SPR EA1N AND EA2 PROJECTS

DEADLINE 5 – FURTHER COMMENTS ON APPLICANTS' ExA.AS-3.D3.V1 EA1N Outline Watercourse Crossing Method Statement - Version 01 01 [\[REP3-048\]](#)

Interested Party: SASES

Date: 3 February 2021

East Anglia TWO and East Anglia ONE North
Appendix 24.7 Figure 3:
Location of Aldringham Court (Raidsend)

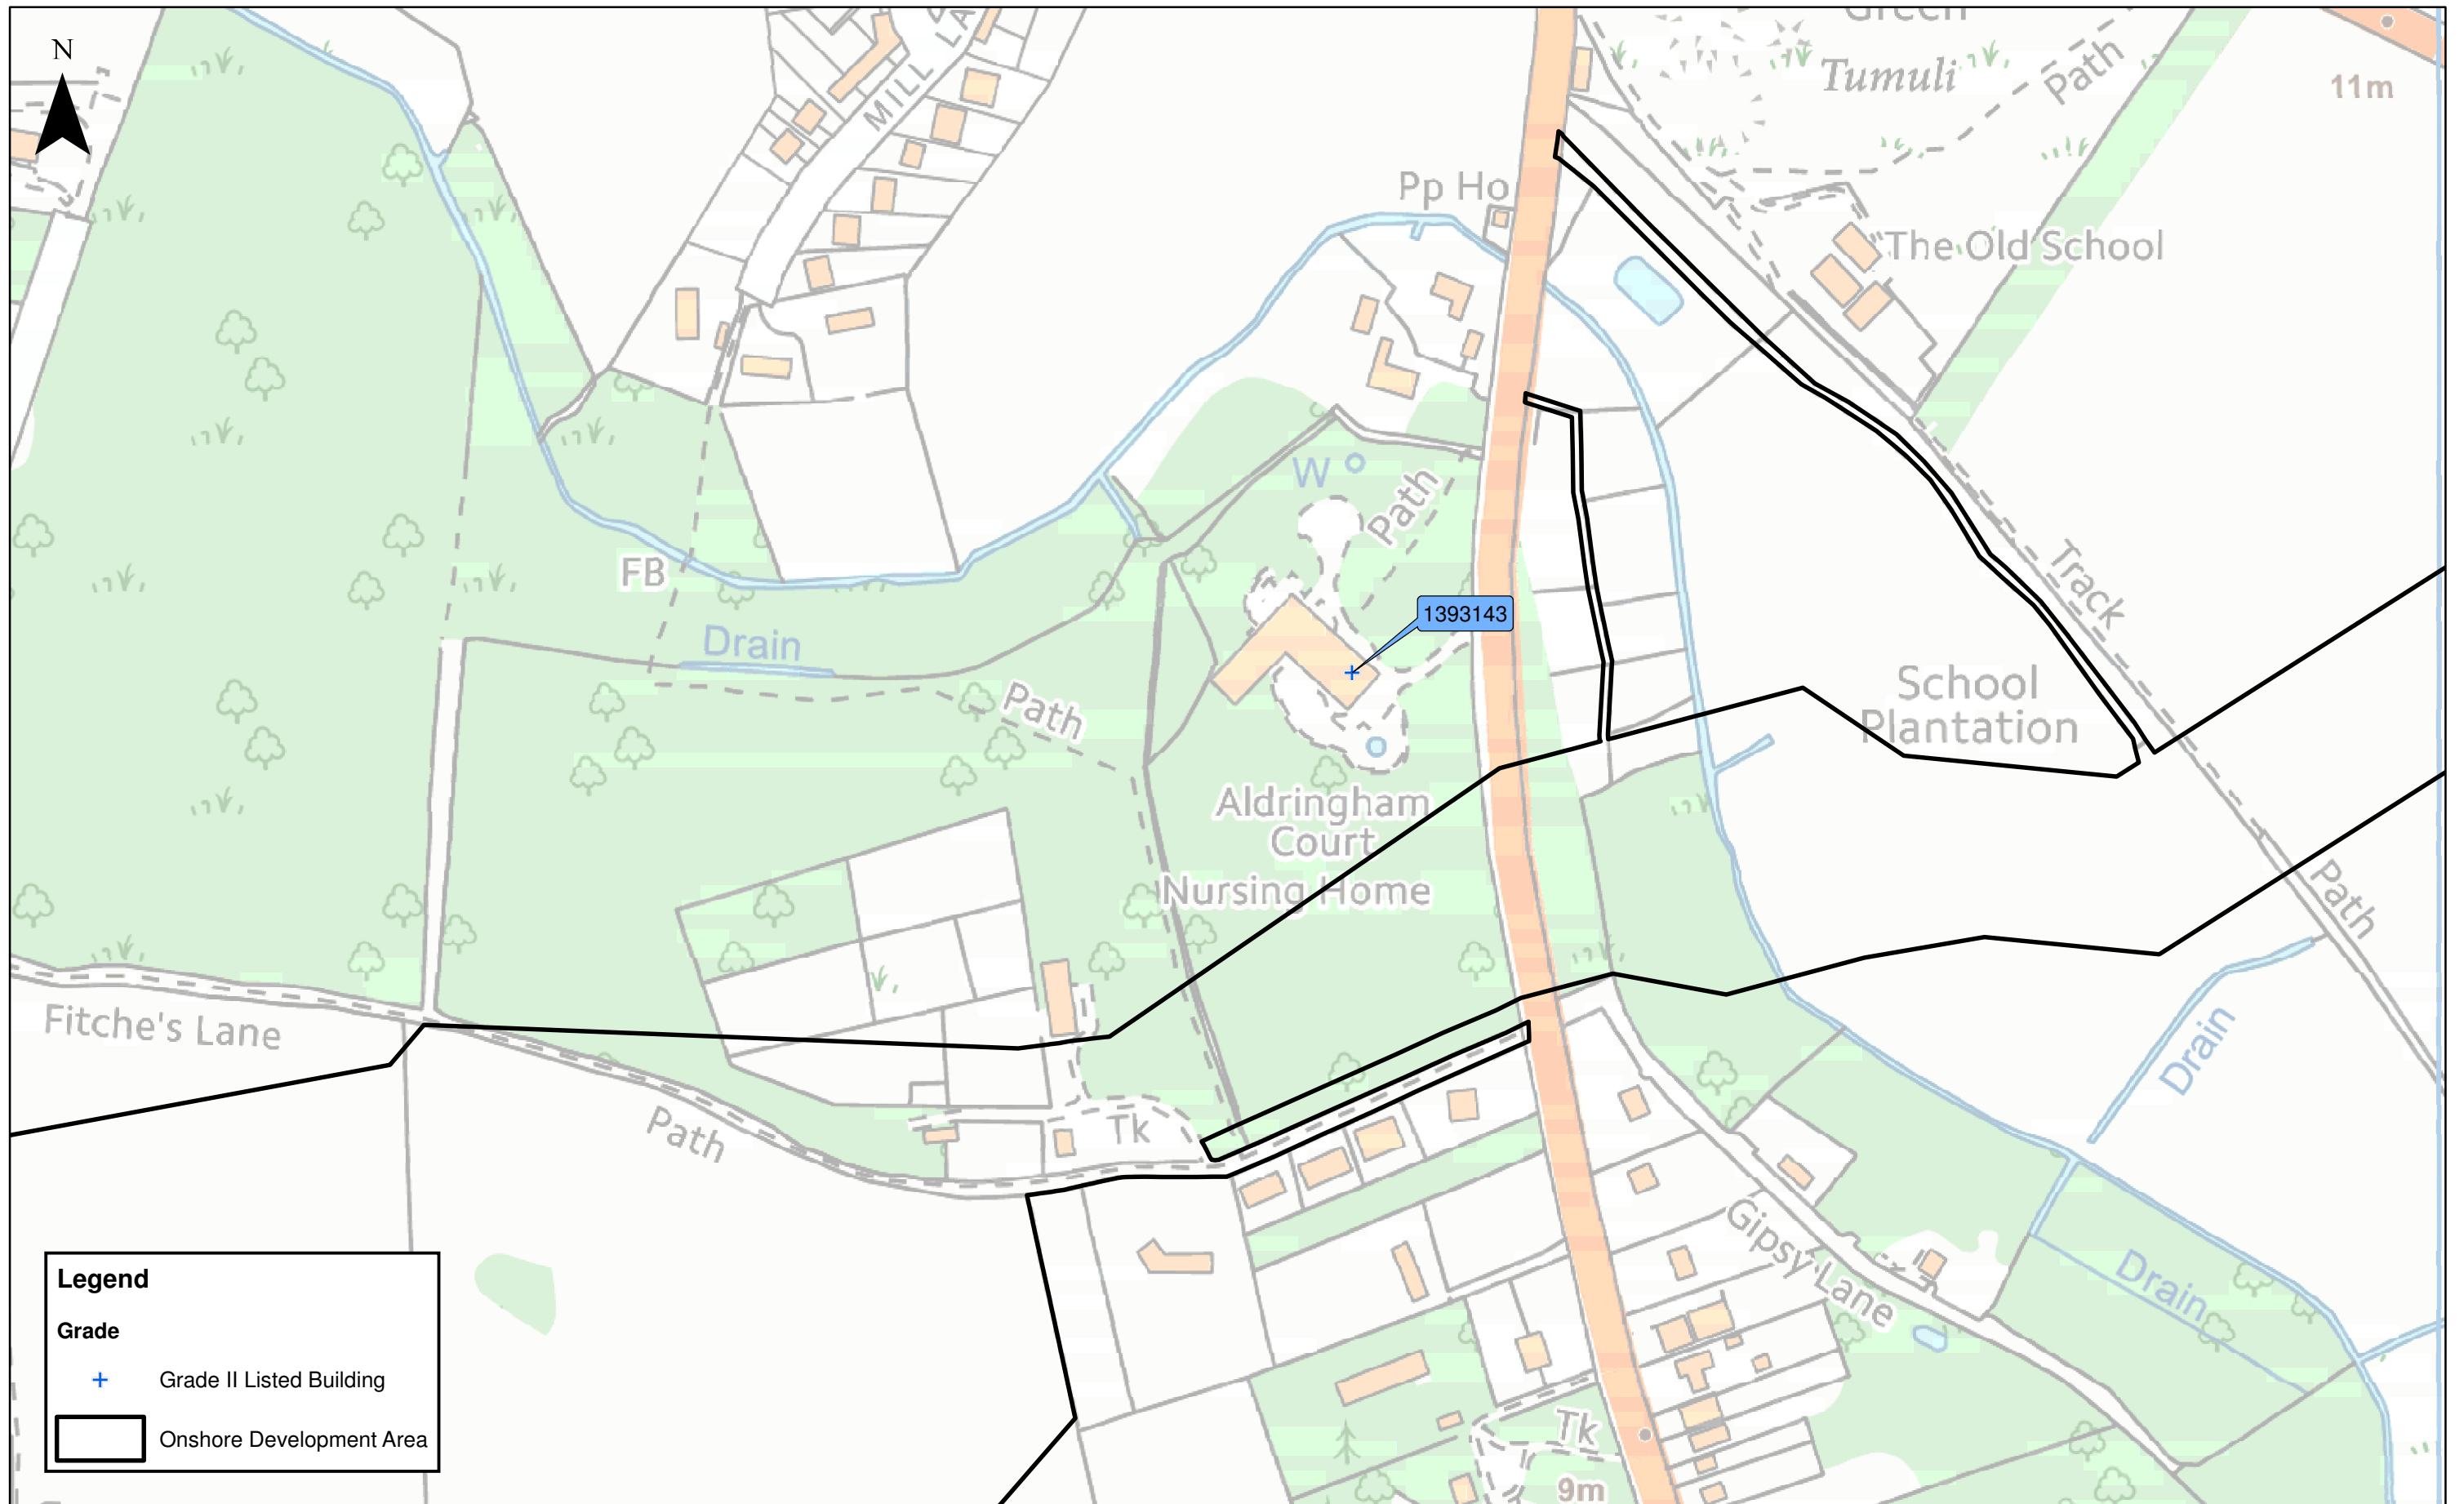
The Local Authorities, SASES and other Interested Parties expressed concerns during earlier phases of Consultation and during these Examinations regarding the environmental impact of the Applicants' choice of a crossing place between Aldringham Court (formerly Raidsend) and the Gipsy Lane / Fitches Lane road crossing on B1122 Aldeburgh Road in Aldringham.

A major concern has been the potential impact on the roadside landscape and the setting of Grade II listed Aldringham Court together with the damaging loss of tracts of woodland. Another has been the proximity of construction activities to residents in the close vicinity during construction phases. The Applicants have made commitments to pre-install cable ducting for the second project during construction of the first project and to reduced widths of the cable route(s) across the woodland to the west of Aldeburgh Road and on the east side up to a line 40 metres from the river.

However, there is no commitment as yet on the positioning of the river or road crossing place within the present 93 metres order limits width between Aldringham Court and Fitches Lane. There is no clarity on how much woodland would be cleared save that only 5 metres width would be preserved between Fitches Lane and the construction activities on Work No. 20.
